FINAL GRADING AND EROSION CONTROL PLANS
FALCON MEADOWS AT BENT GRASS FILING NO. 4
FALCON, CO 80831 - EL PASO COUNTY
CHALLENGER COMMUNITIES, LLC

PUDSP-20-005 (FALCON MEADOWS AT BENT GRASS PRELIMINARY PLAN)
SF-22-XXX (FALCON MEADOWS AT BENT GRASS FILING NO. 4)

Engineering Review
08/19/2022 2:51:35 PM
jdrice
JeffRice@elpasoco.com
(719) 520-7877
EPC Planning & Community
Development Department

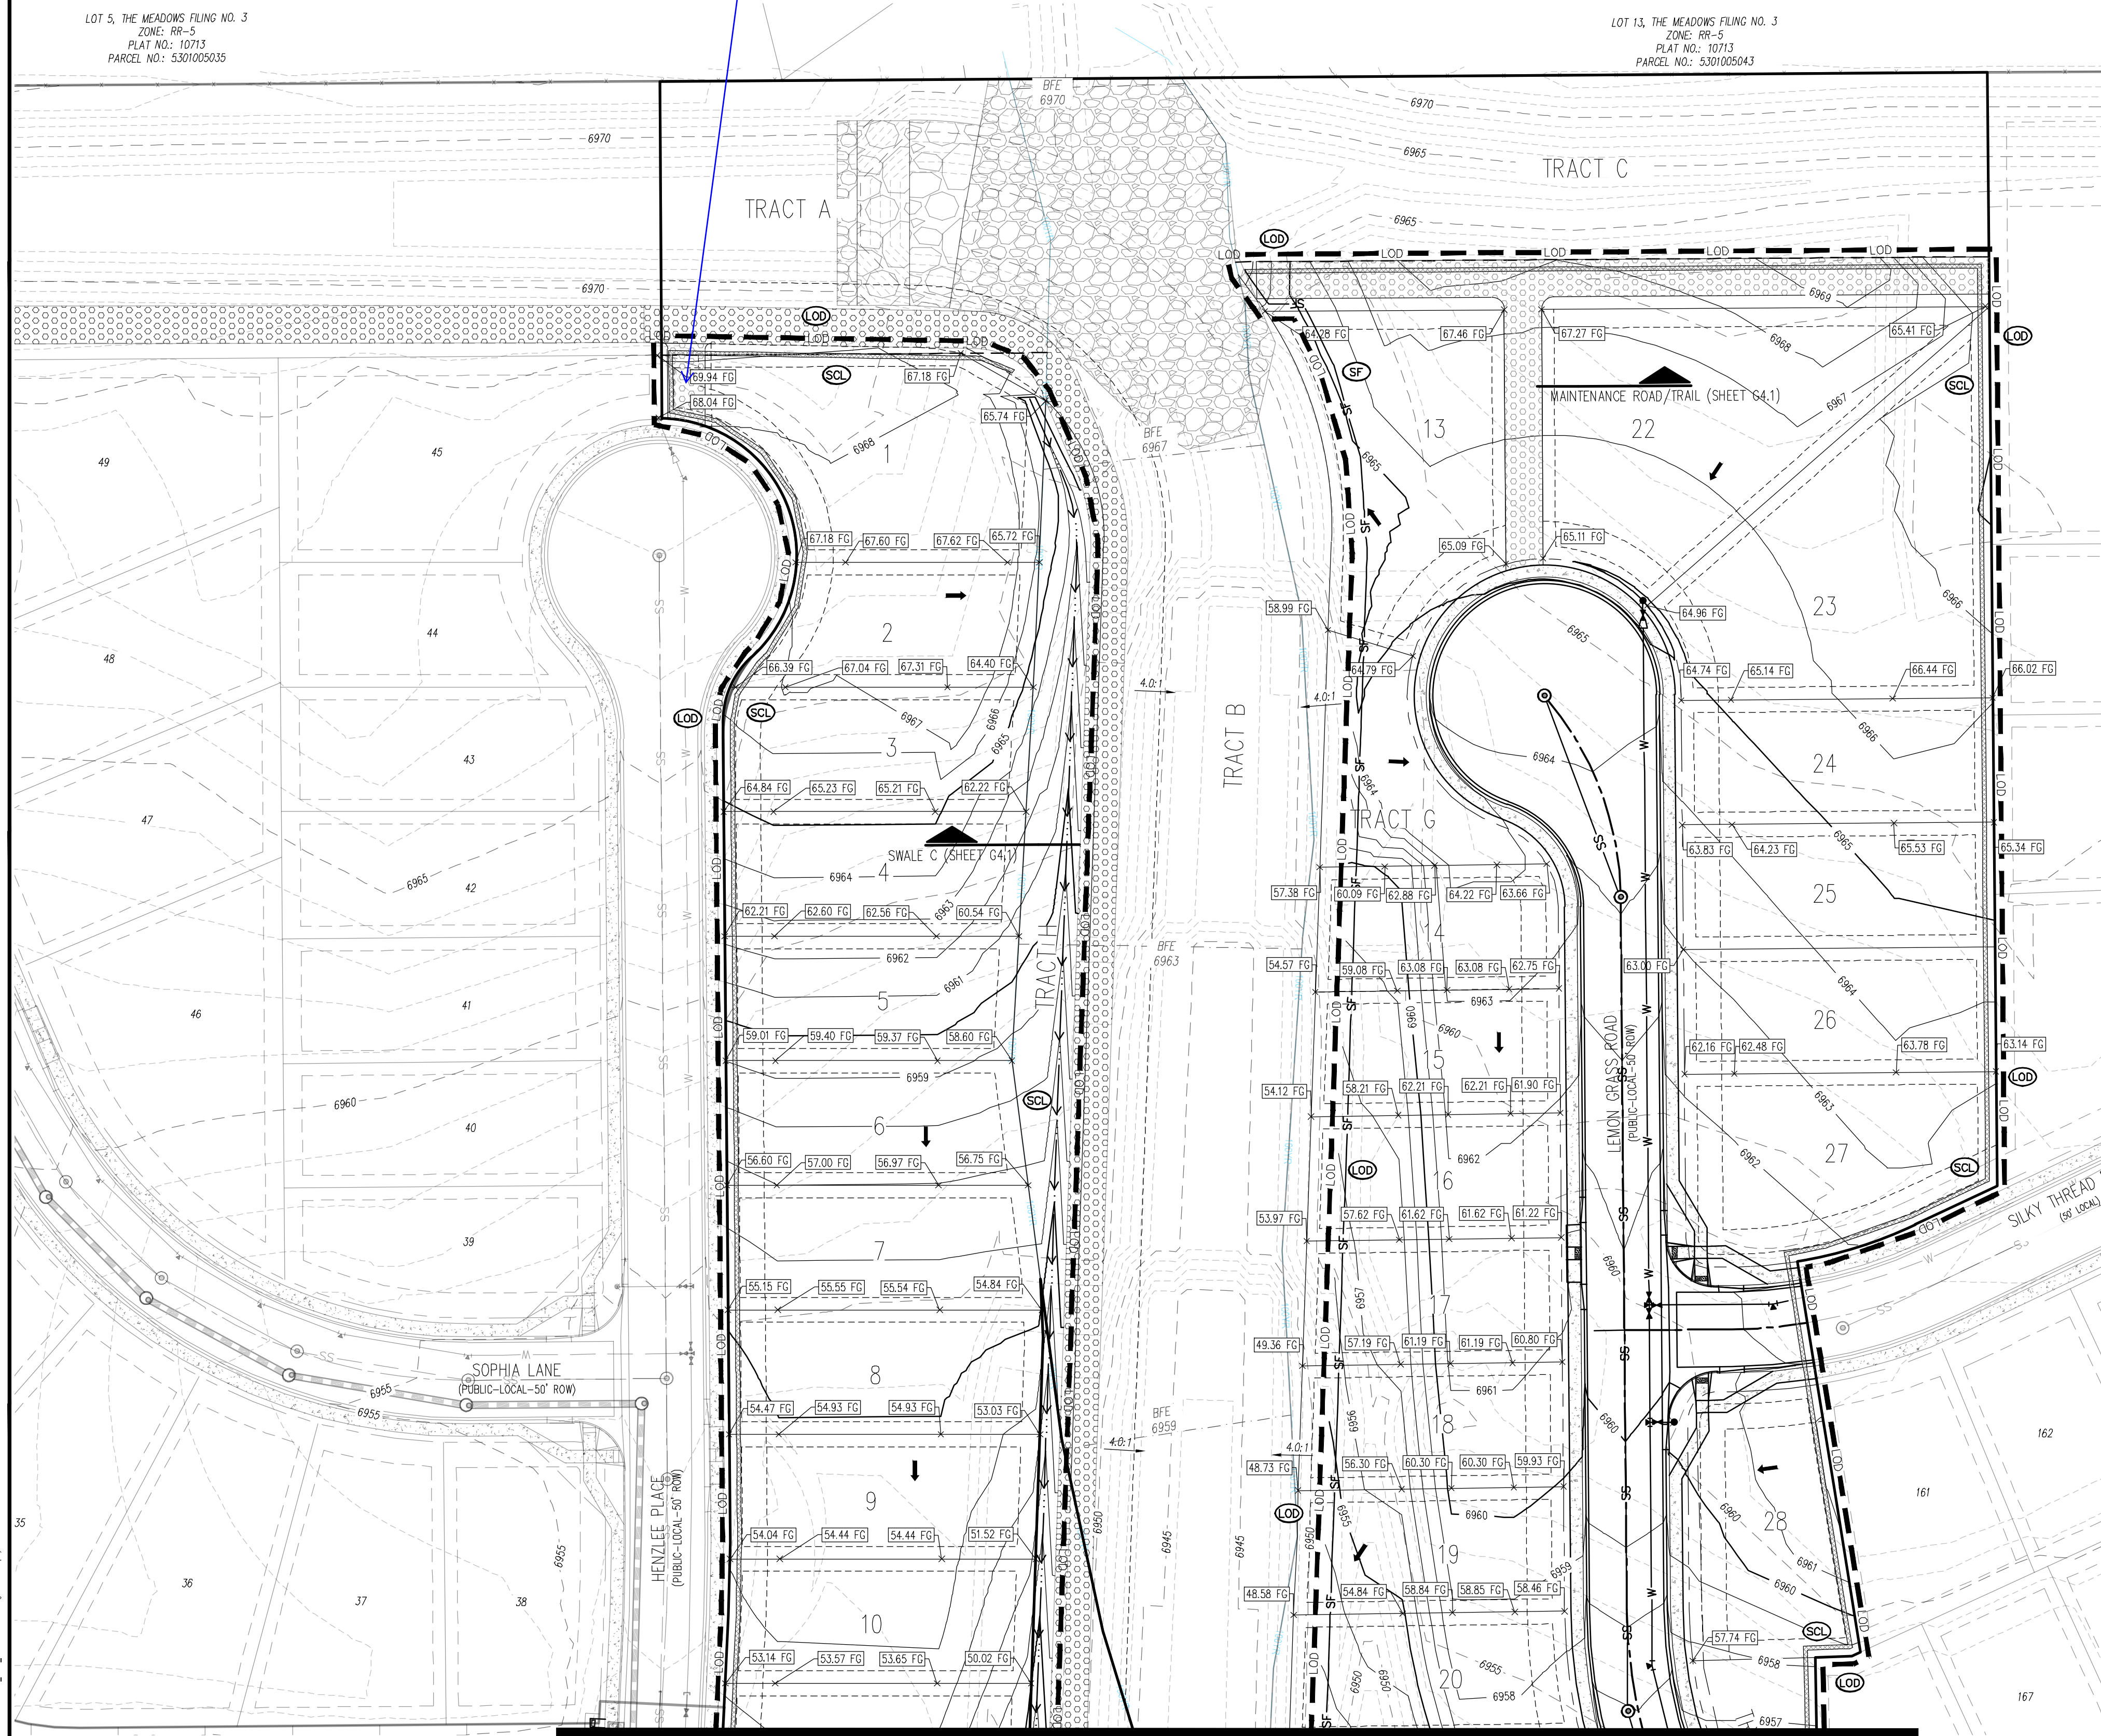
show drainage flow arrows on this sheet.

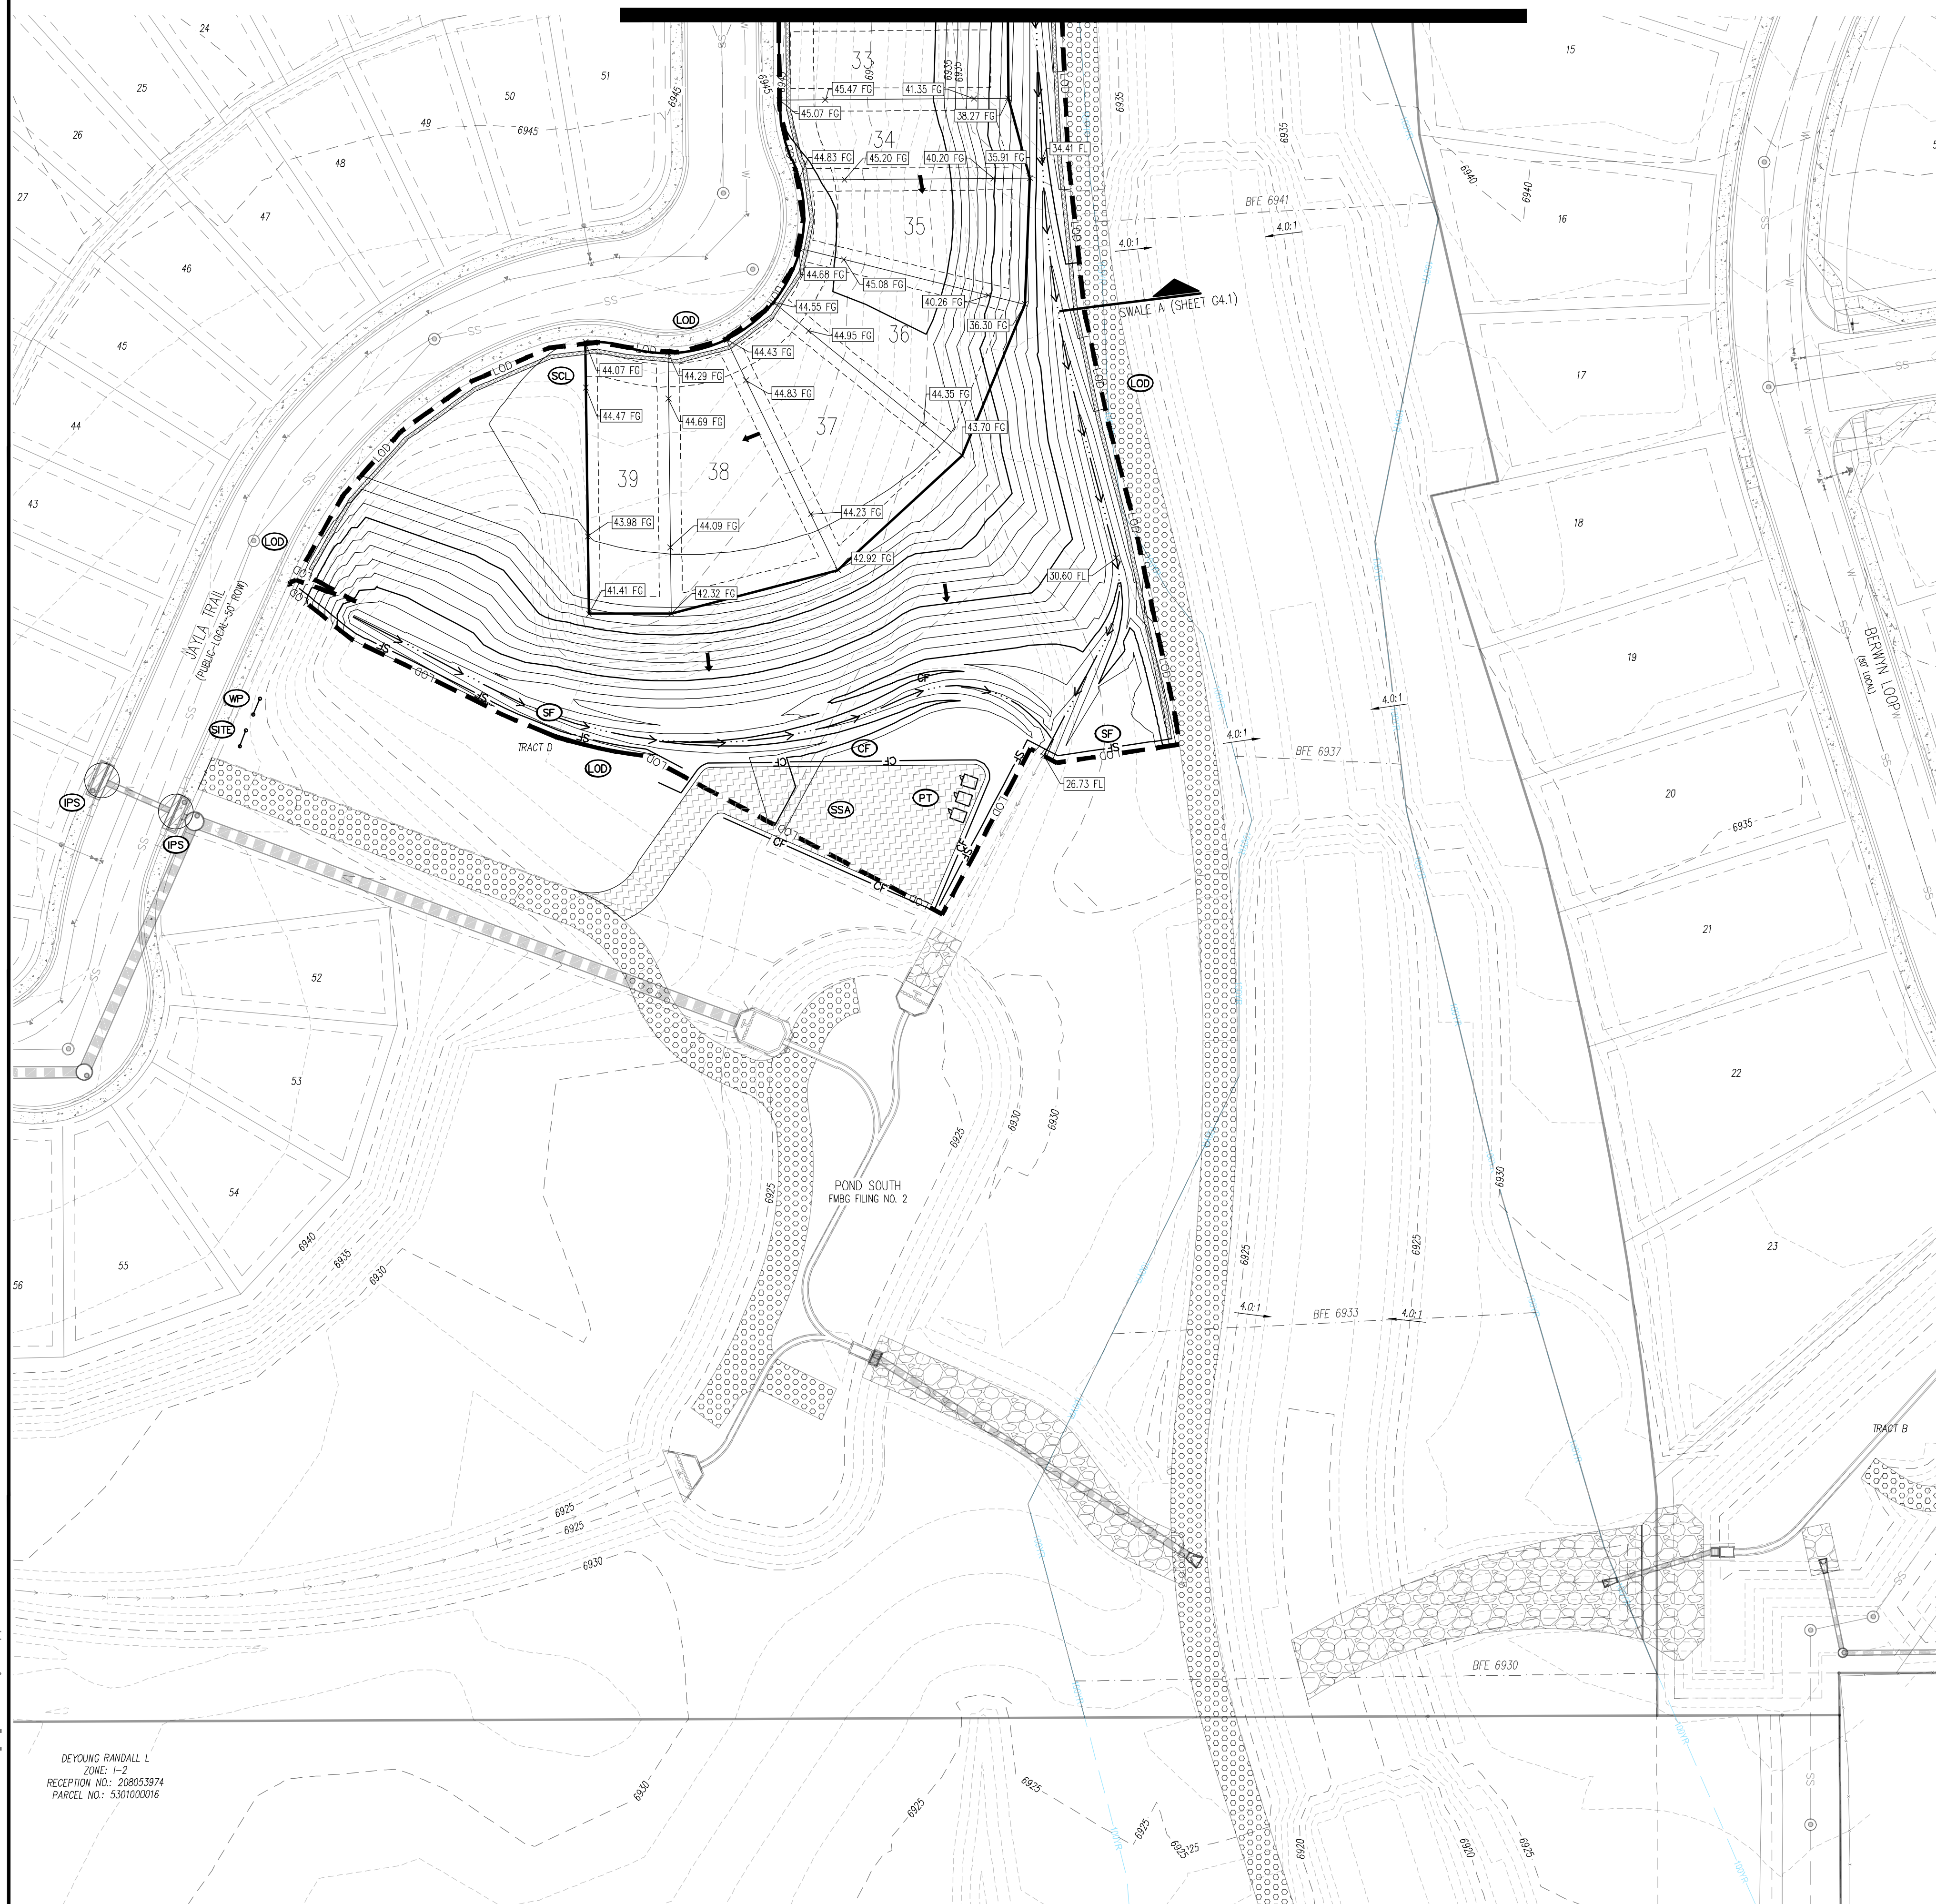
show drainage flow arrows on this sheet.

About an acre of disturbance is tributary to this point, with no outlet to the pond. Per the GEC Checklist, areas greater than an acre need a TSB. And the SF detail states that SF is only appropriate in areas where the tributary area is ≤ 1.14 acre per 100' of SF.

So consider adding sediment traps upstream as needed, more upstream BMPs, a TSB here, or if the downstream pond is going to be used as a TSB show conveyance to the pond (via a temporary or permanent slope drain or rundown).
